Longfield Solar Farm

Statement of Common Ground – Environment Agency

Document Reference : EN010118/EX/8.4

August 2022

Figure 3 : SFRA Fluvial Flood Zone Mapping 65% Climate Change - Fluvial Modelling Report

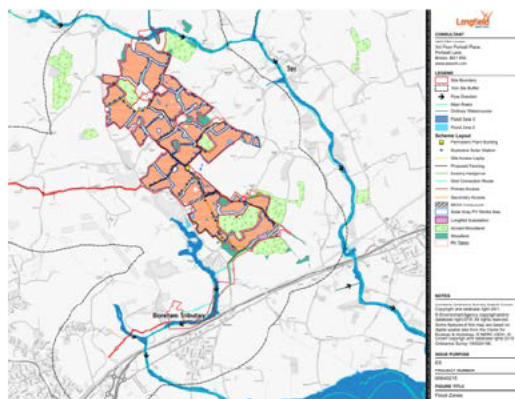
12	Development areas and Flood Zones	Appendix A of the FRA shows the layout of the development. It should also have a map showing built development in relation to the flood zones (including climate change, for the lifetime of development and beyond, as a sensitivity test). [Statutory consultation]	The updated FRA is available in Appendix 9A Flood Risk Assessment [EN010118/APP/6.2] . Figure 3 shows areas where above ground development may be located in relation to Flood Zones.	Agreed
